City of Albuquerque

Project Title: COMFORT DENTAL MENAUL Building Permit #: _____ City Drainage #: 14182068

Re: Comfort Dental Coronado, 5820 Manual Blvd, Traffic Circulation Layout
Architect's Stamp dated 07-24-13 (H18-D068)

**Re: Comfort Dental Coronado, 5820 Menaul Blvd, Traffic Circulation Layout
Architect's Stamp dated 6-05-13 (H18-D068)**

**TCL.03**

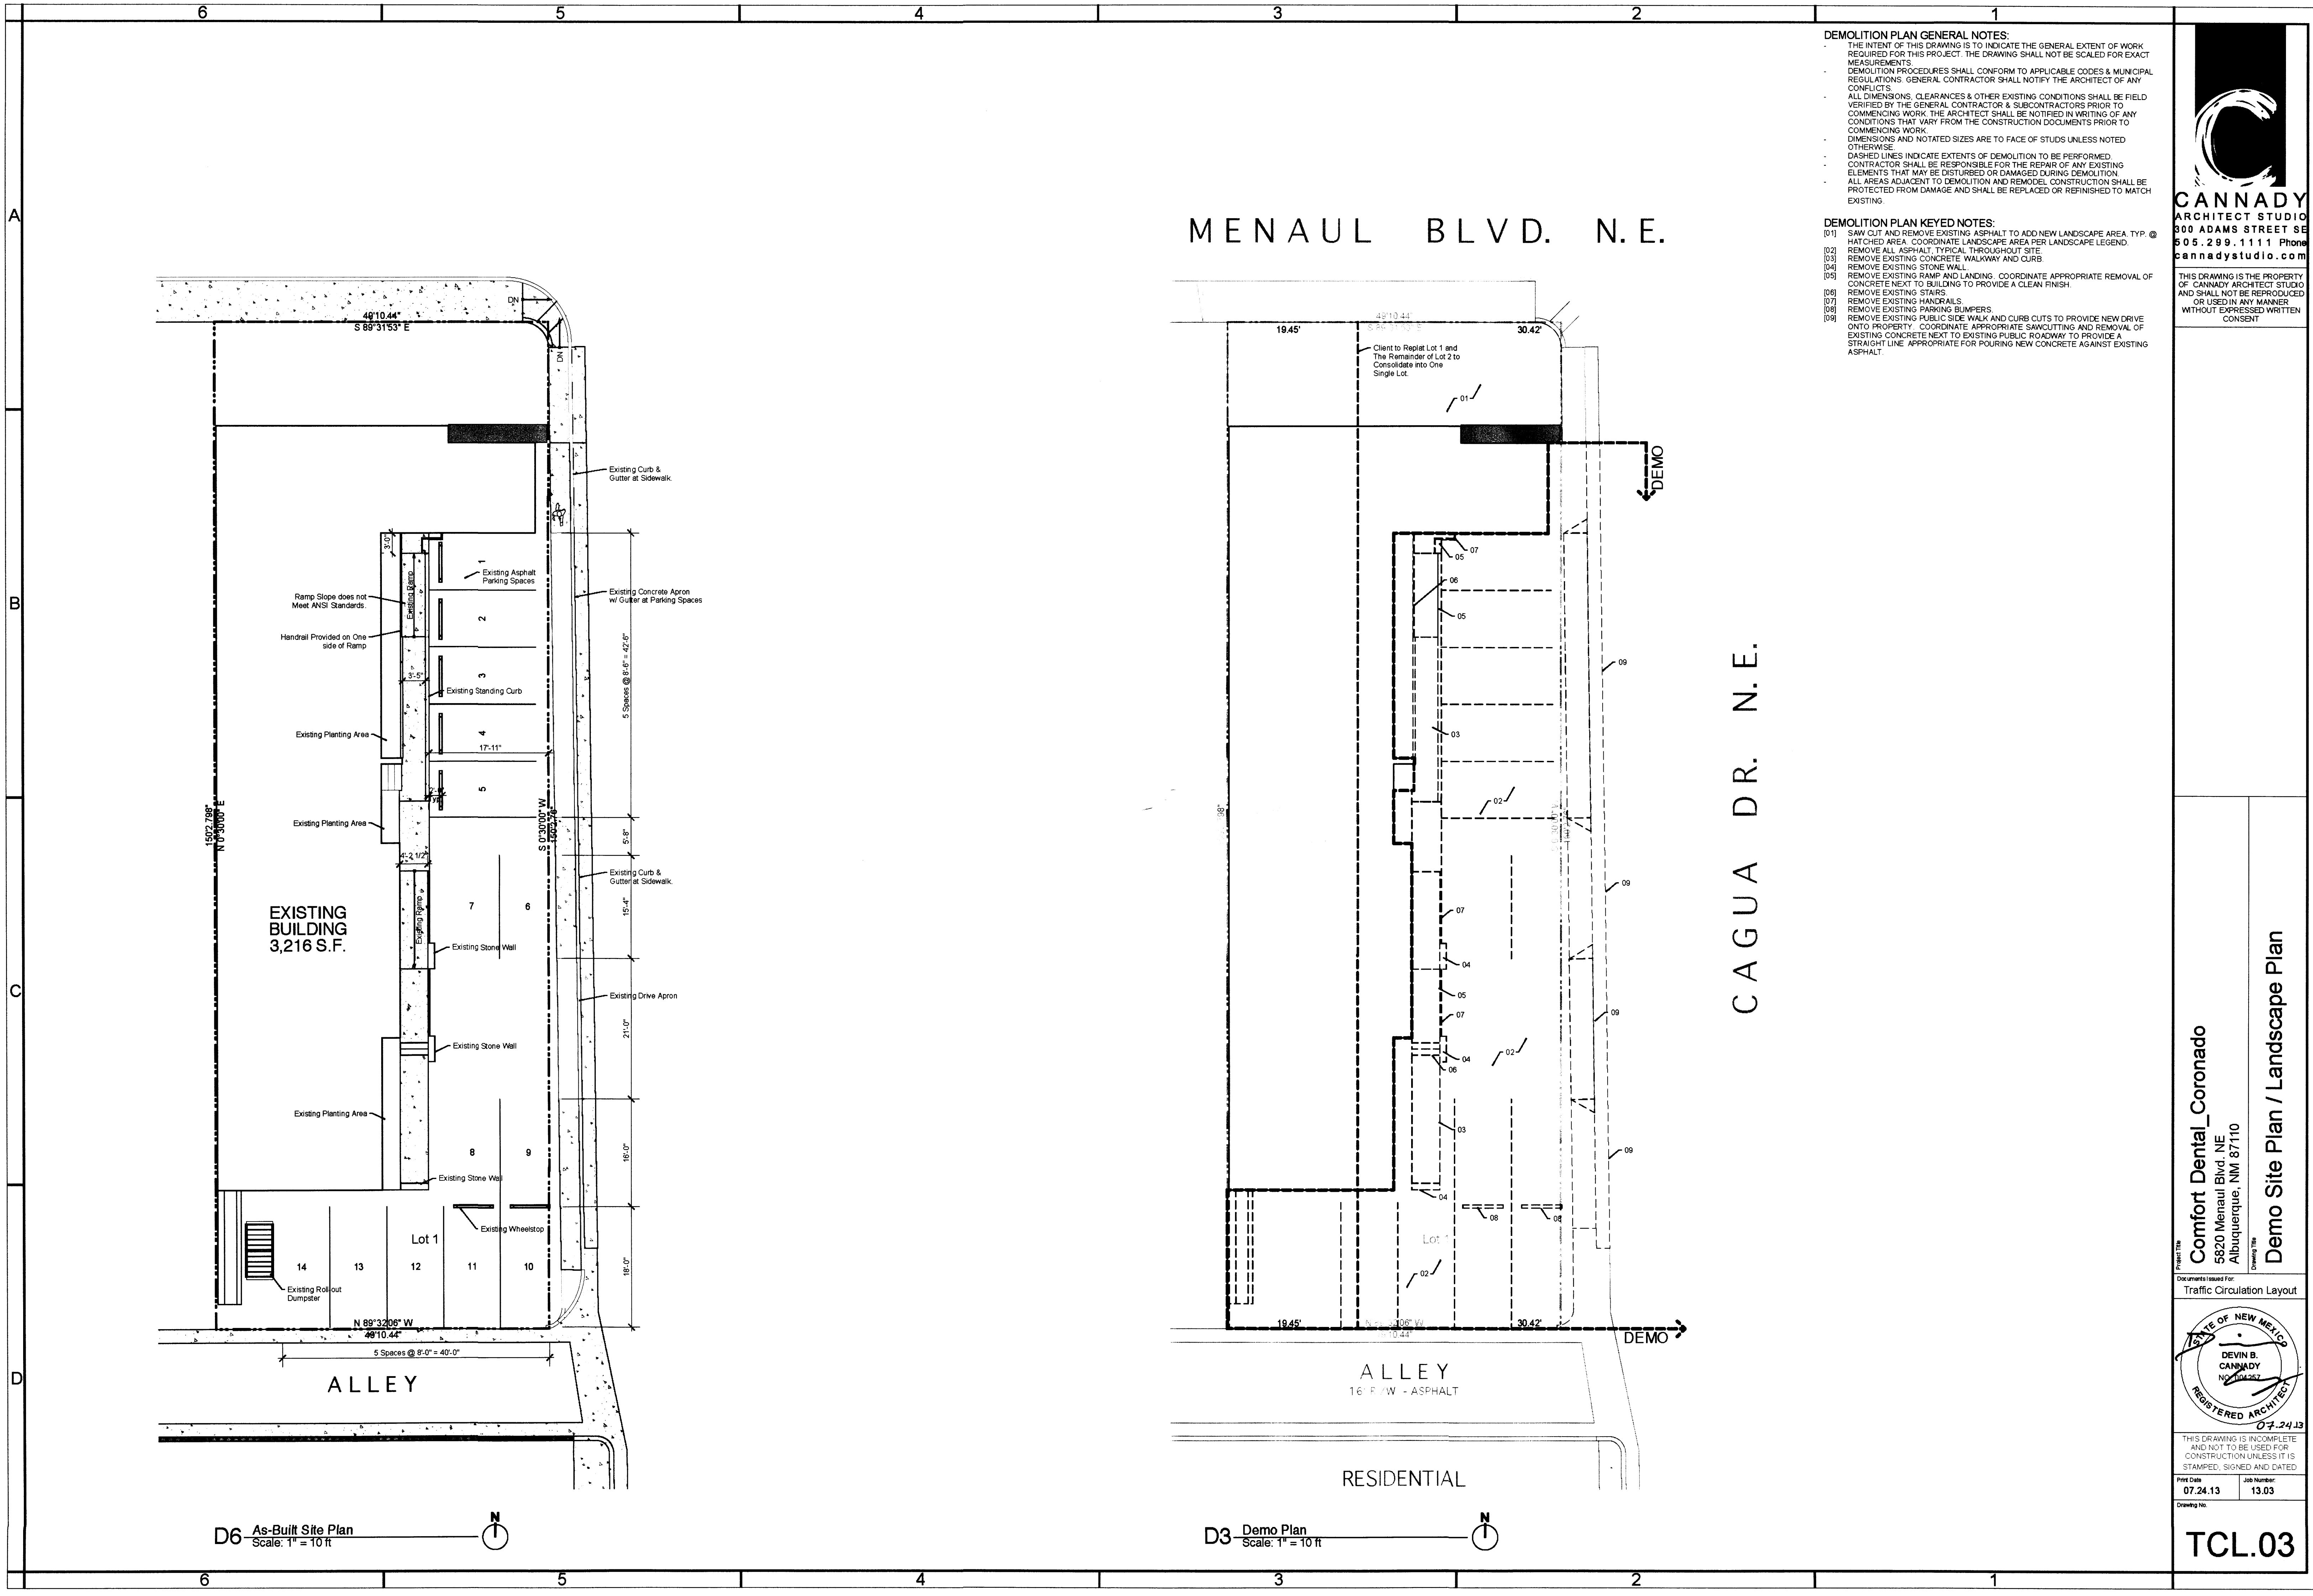
8. Demo plan conflicts with proposed site plan. Please differentiate between new concrete proposed and existing to remain. There are inconsistencies between demo and proposed.
